Existing Plat

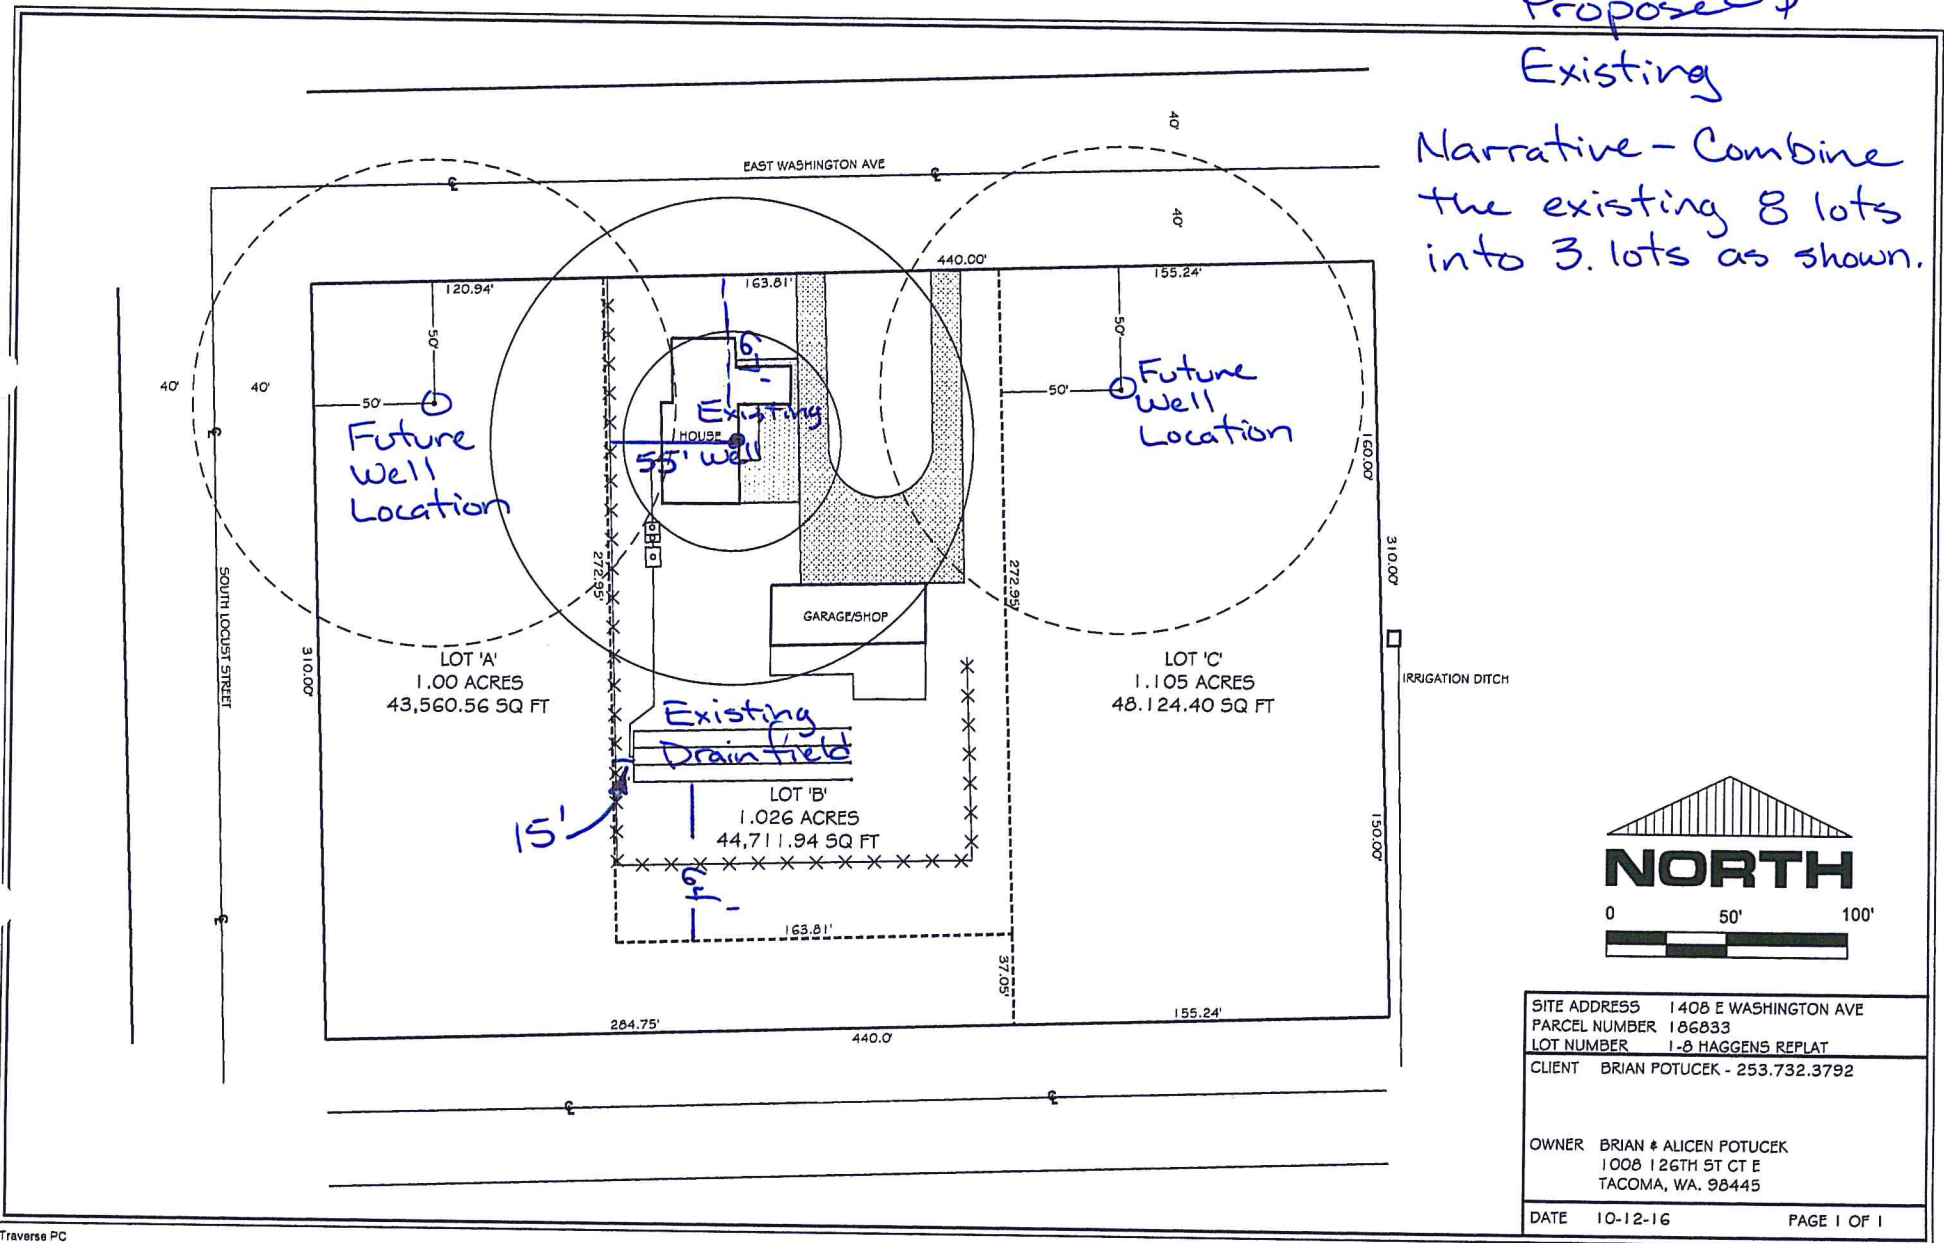
I have no concerns regarding this EXCEPT for verifying that the parcels reflected on the Plat of record are indeed correct, and were not previously combined, as there appears to be a discrepancy between the Platted lines and the Tax parcels per our GIS. In reading through the review, it sounds like Doc was already looking into this.

Proposed

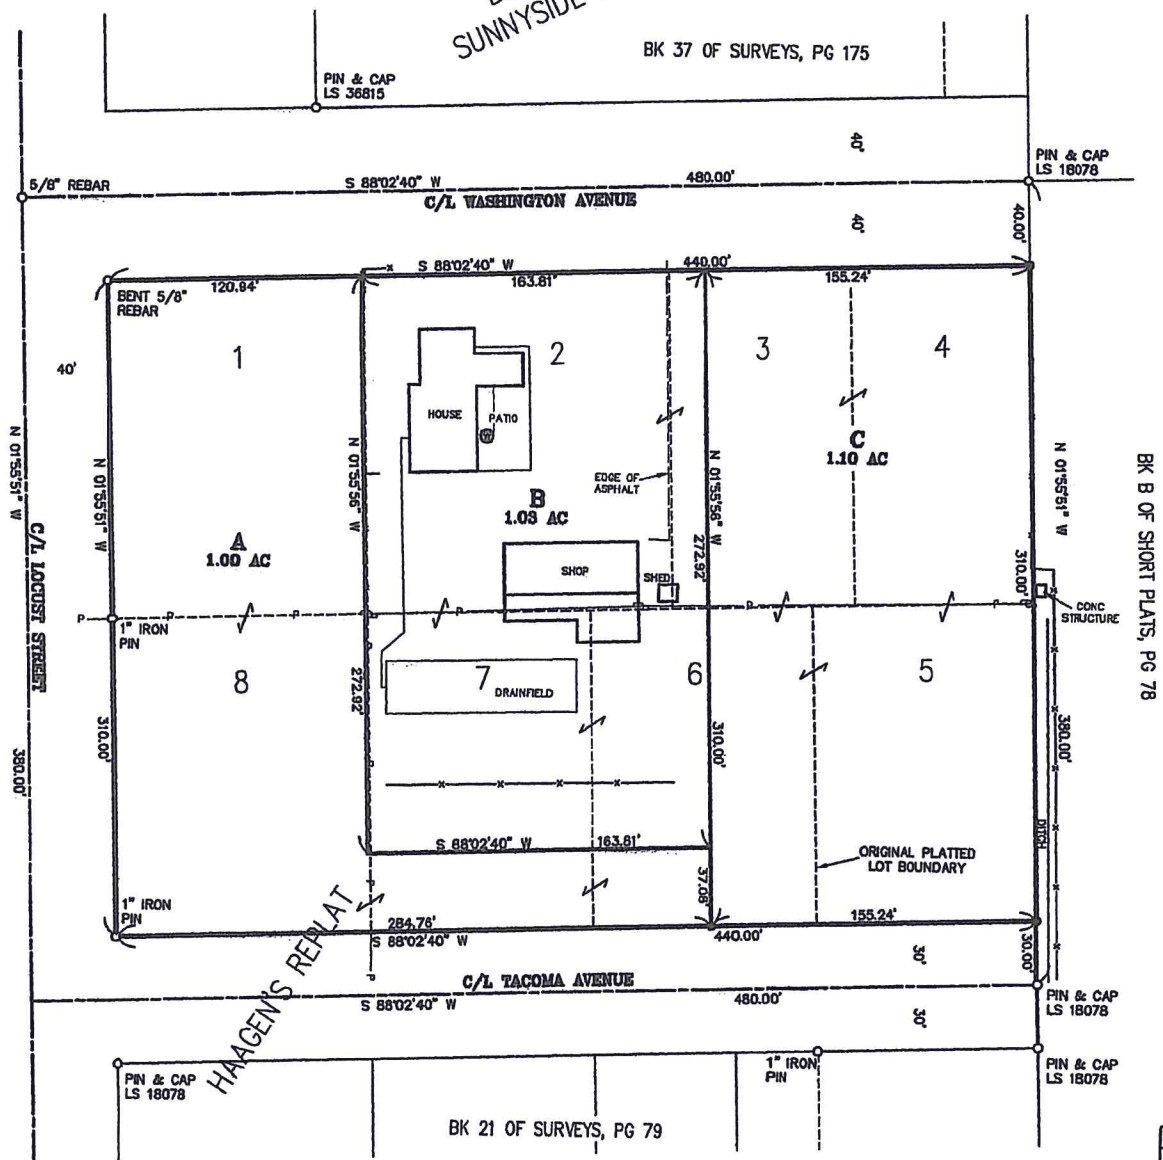
I have reviewed this application and see that the well and future well sites meet all required setbacks. Careful planning will need to be done in the development of lots A and C as the space to work with is very small.
